Subject: FW: Application_Ref_No=AW/164/20/HH

Subject: Application_Ref_No=AW/164/20/HH

We wish to submit an objection to the planning application above. These are retrospective plans, the first ones Ref: AW/272/19/HH were not adhered to by the builders and a totally different and unacceptable roof was constructed.

B~ ROOF OVERHANG ADDED 7/20
A~ CLIENTS REVISIONS 6/20

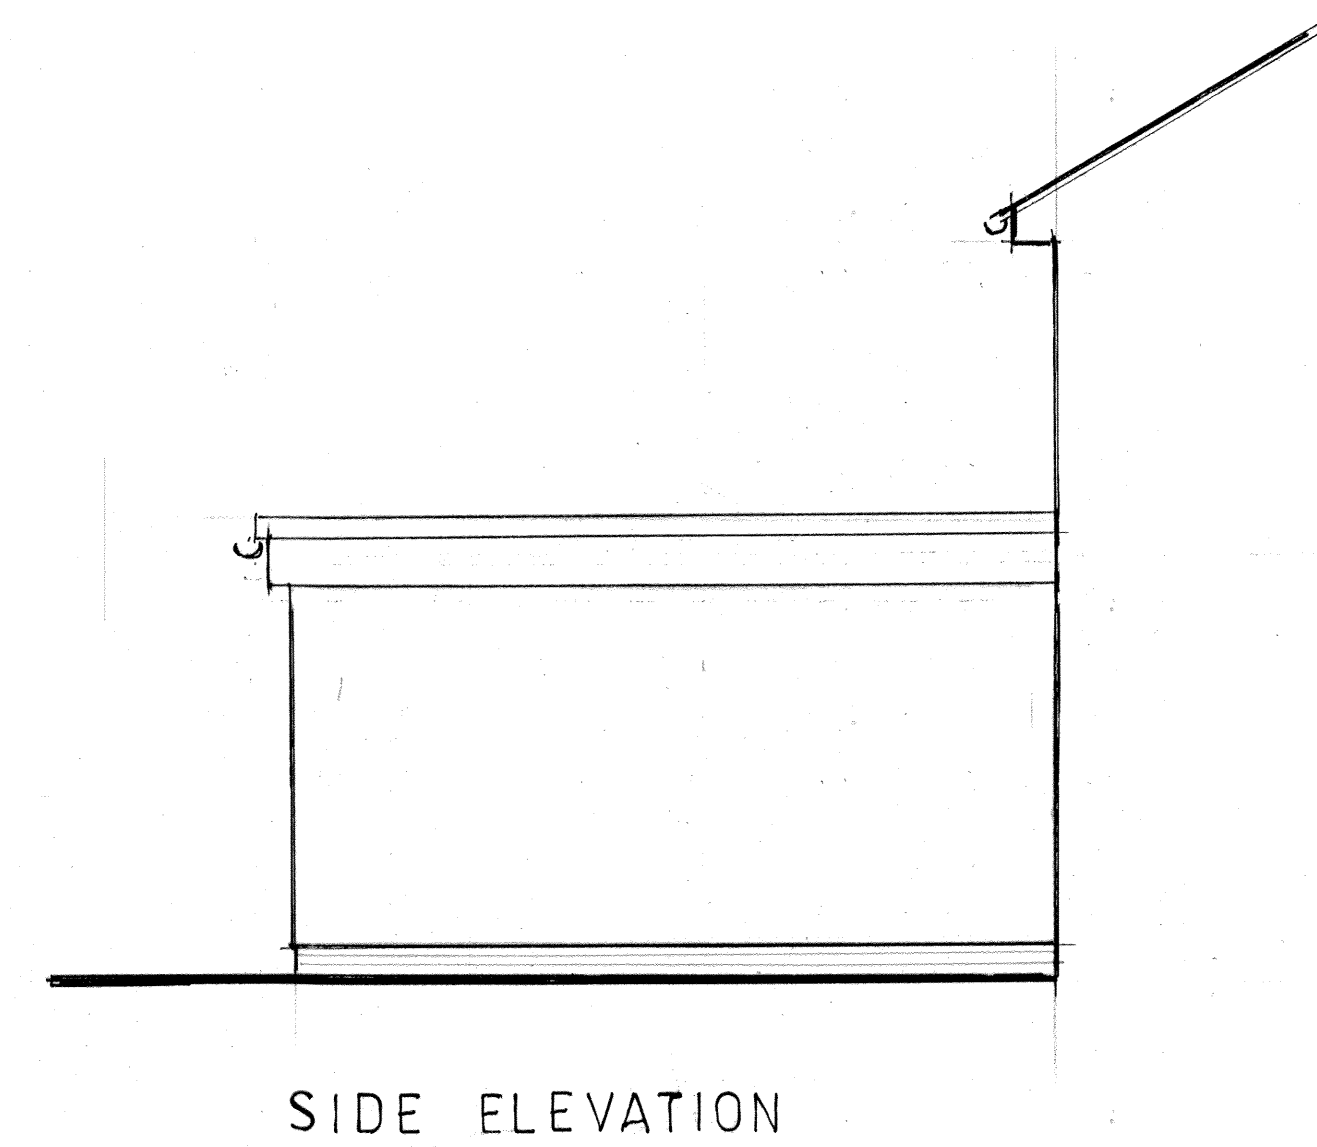
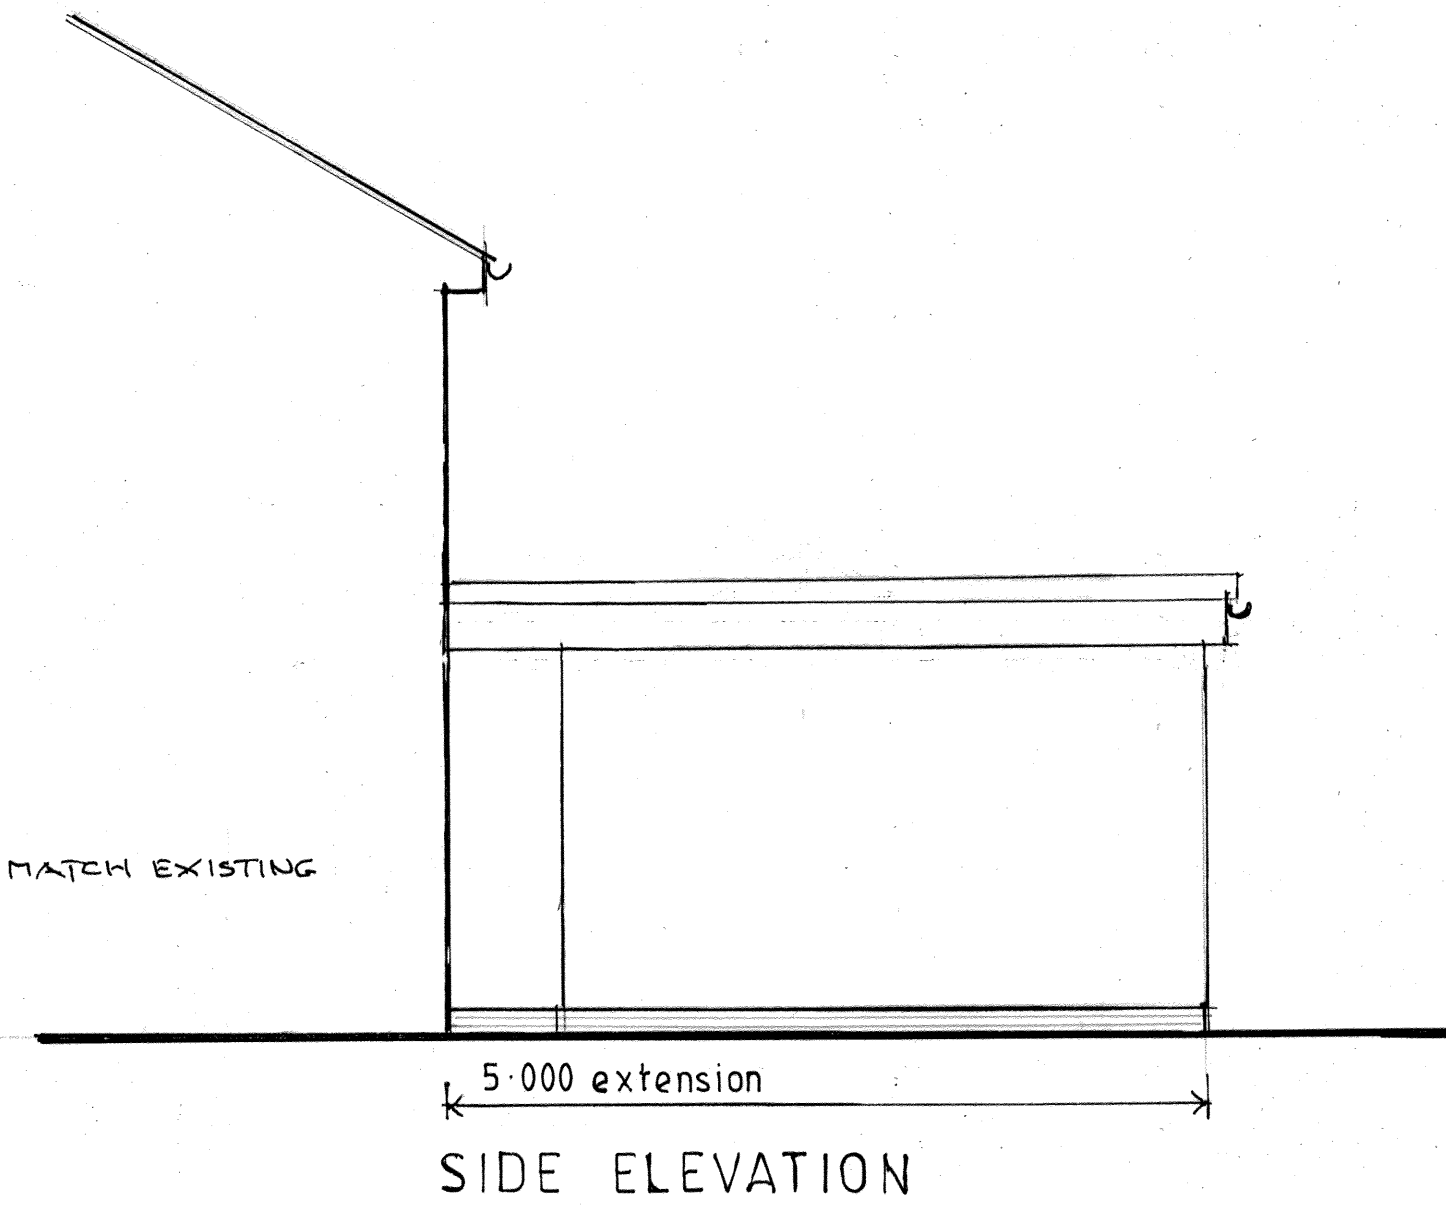
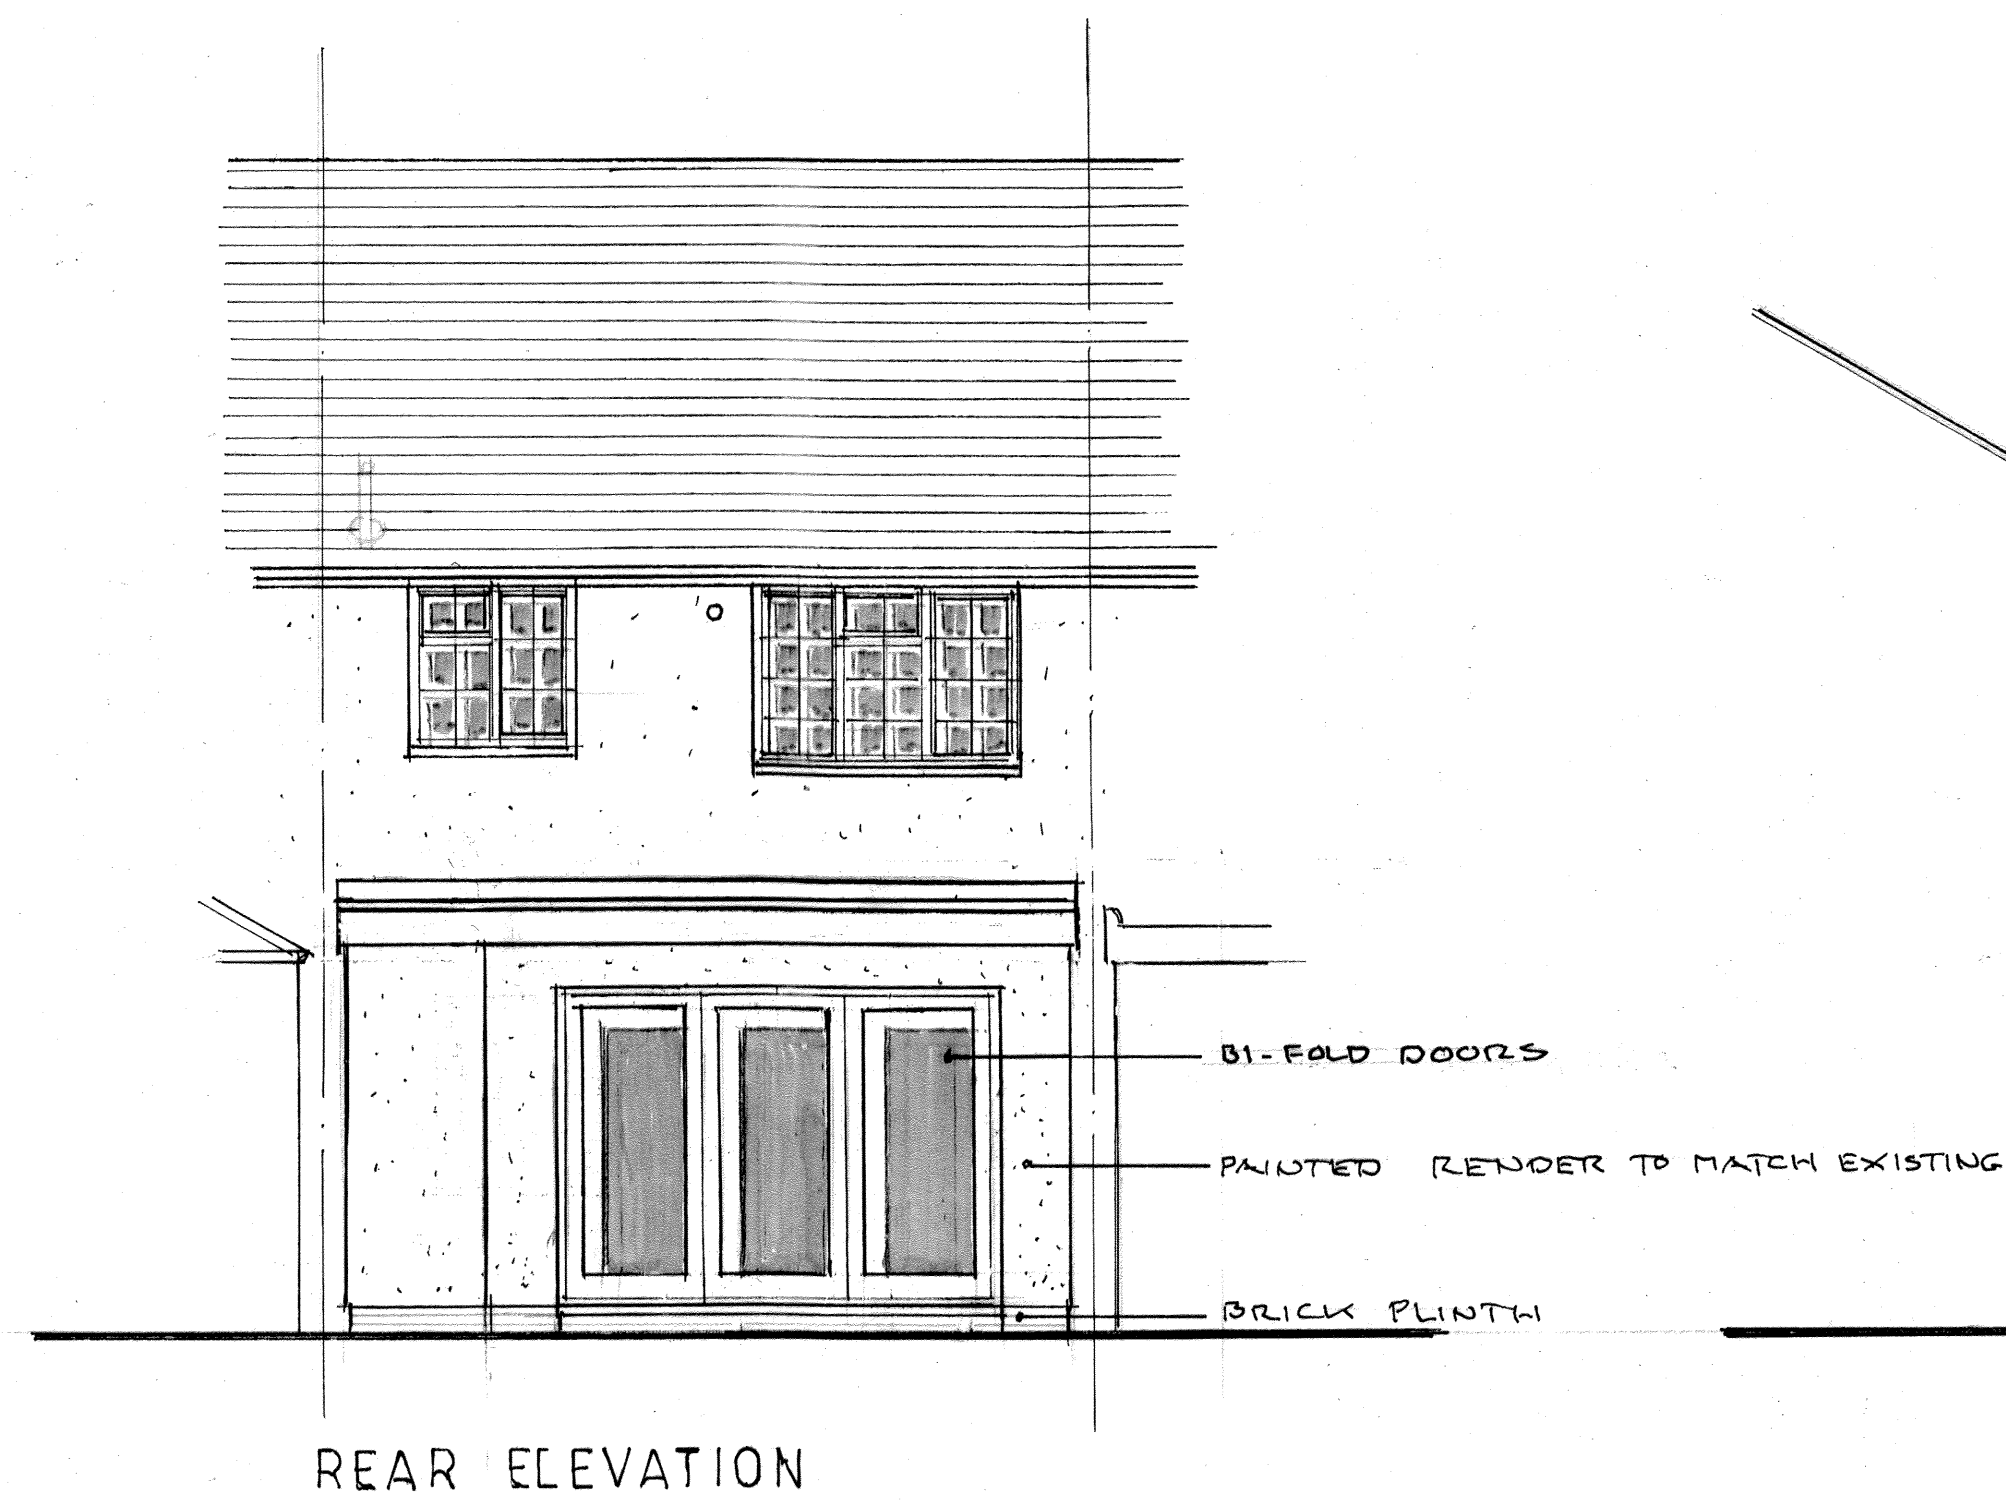
The roof and fascia are too high and not in keeping with the style and character of the existing properties either side.

The width of the roof is in excess of the measurements shown on the plan thus giving no room for maintenance to our property.

The depth of the fascia is in excess of the measurements shown on the plan.

There is an incline to the roof not shown on the plan.

The front soffet is not shown at all on the plan yet it extends 300mm beyond the building line.

There is no evidence on the plan of where the surface water from this vast area of roof will discharge and into what and where.

The new plans are not consistent with the already constructed building and do not represent accurately what has been built..
